Application for a non-material amendment following a grant of planning permission. Town and Country Planning Act 1990

House:	97	Suffix:	
House name:			
Street address:	Barnham Road		
Town/City:	EASTERGATE		
Postcode:	PO22 0EQ

Alterations to Eastergate Rectory (No 97) and the erection of 3 No. Dwellings with associated access, parking, landscaping, amenity and refuse provision.

Drg No: 1220/13/P/01D

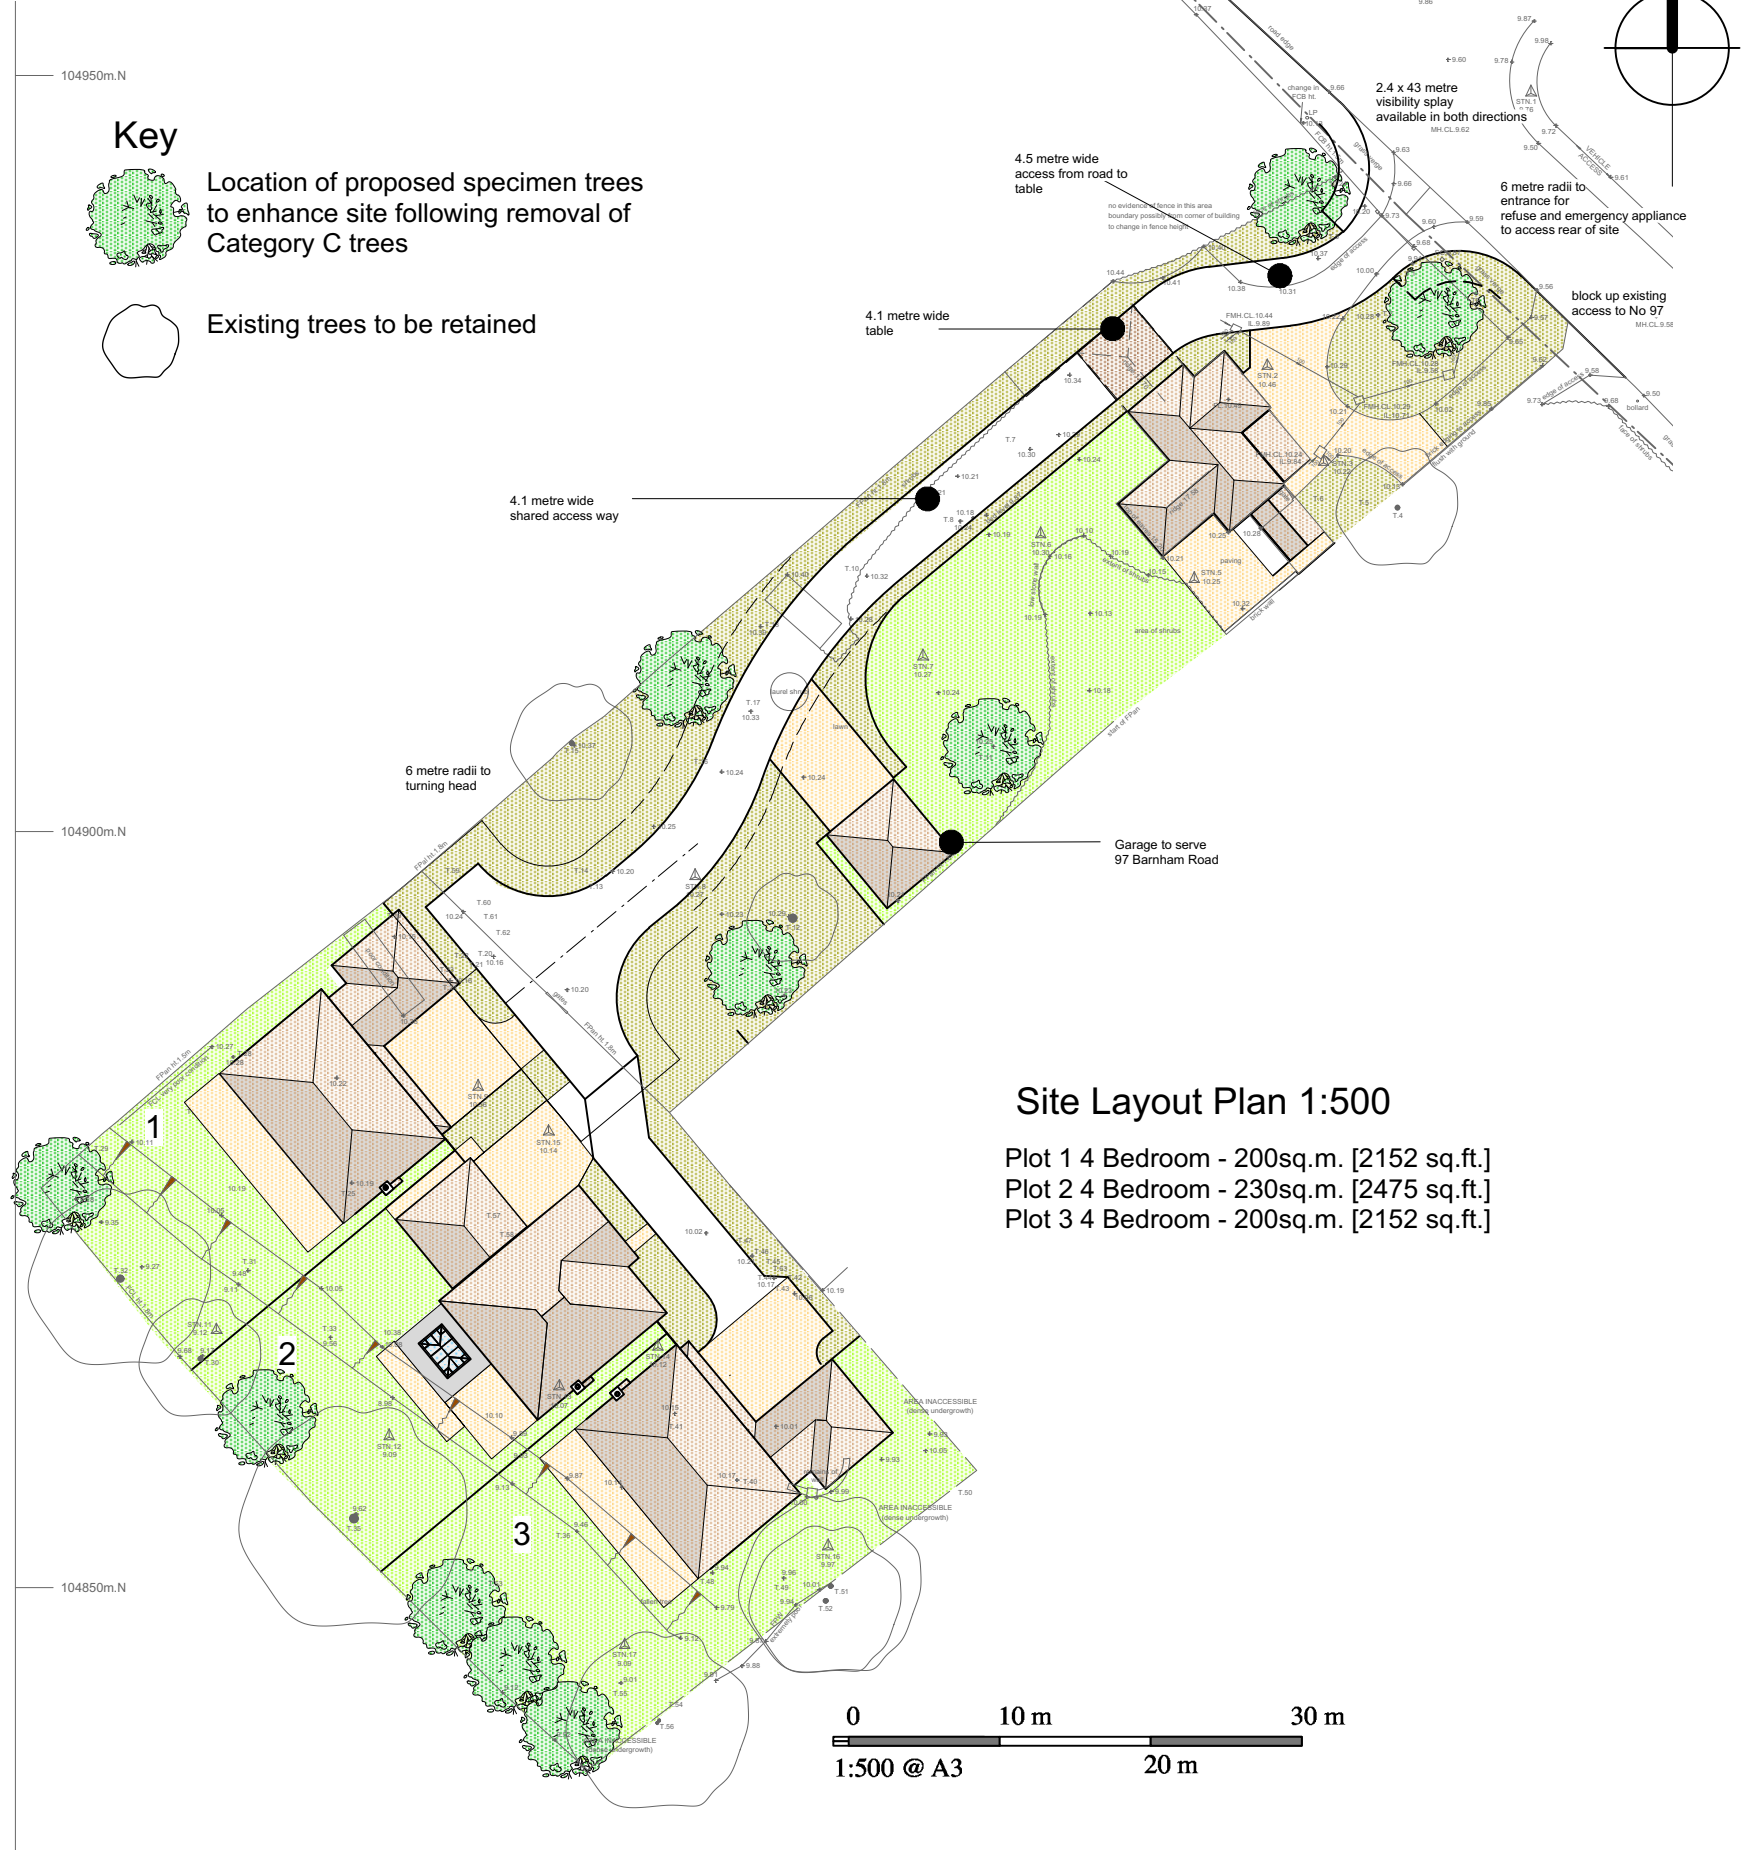
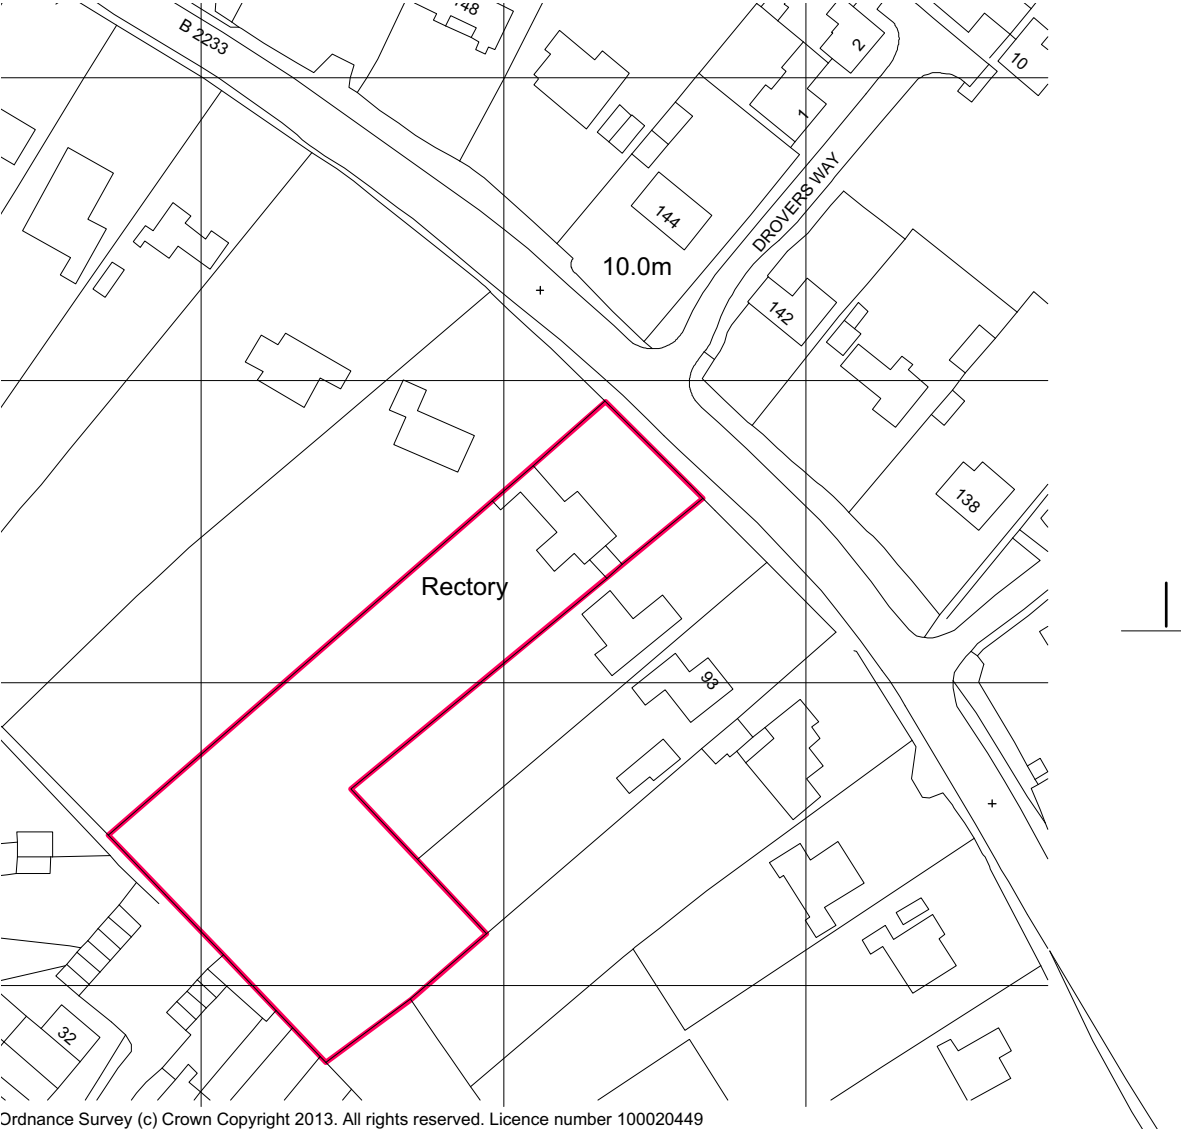
Firstly, to reduce size of single storey side extension to south east elevation to leave a separation distance of one metre from the adjoining property.
